**RE: Applications PR-2023-008710 & SI-2025-00082
U-Haul Site Plan
8200 Jefferson St NE, Albuquerque, NM**

Thank you for your time reviewing the U-Haul Site Plan application for the proposed development at 8200 Jefferson St NE. We received your comments dated February 11, 2025 and have addressed your comments. Below we have copied all your review comments and then provided written responses explain how each item was addressed.

TREE MULCHING DETAIL
NTS

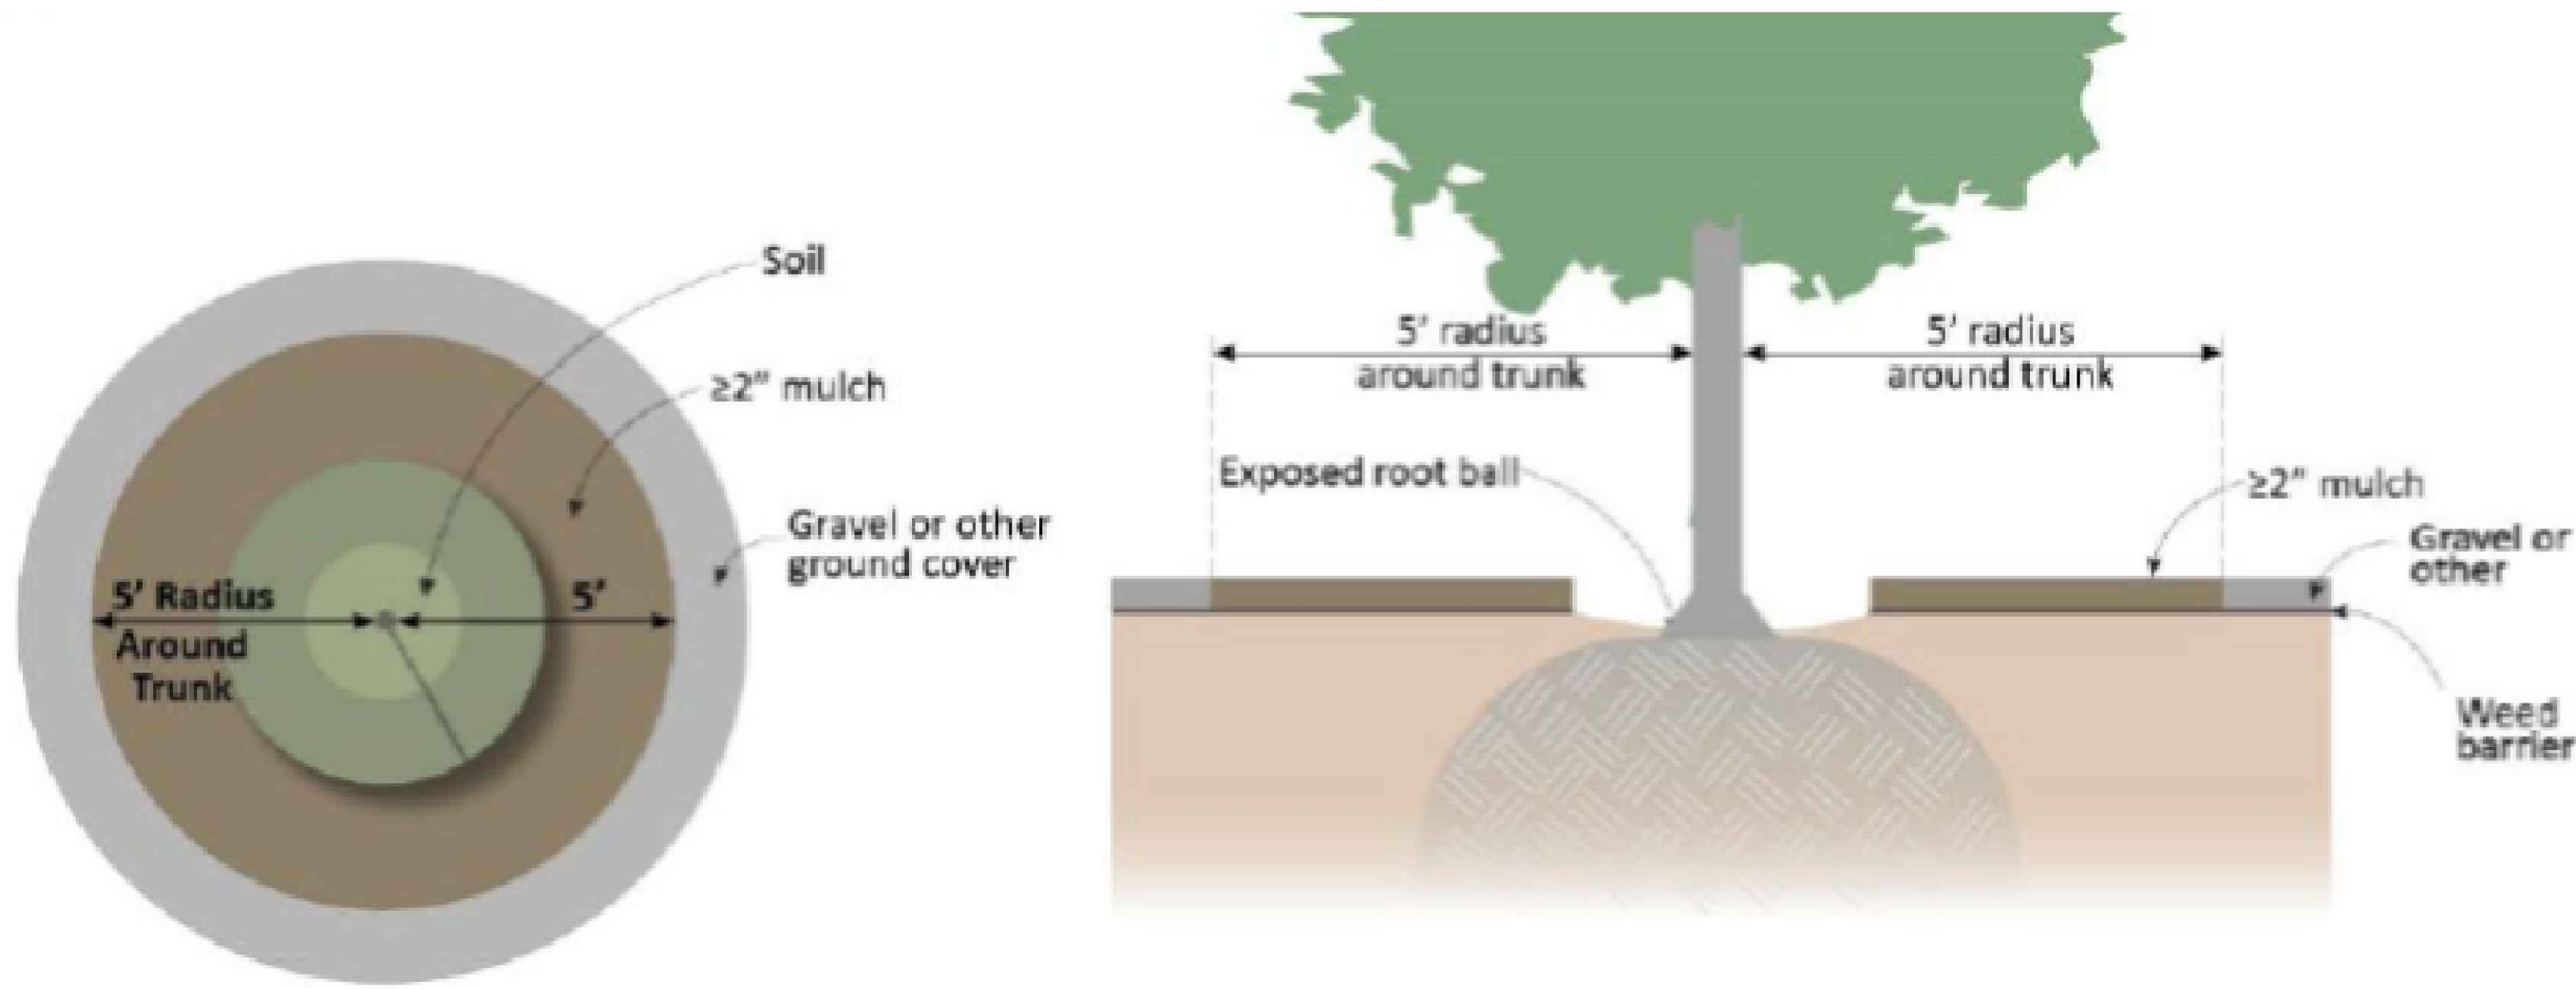
6. Tree planting detail must show 5' radius organic mulch around tree trunk.

ISG Response: This has been updated.
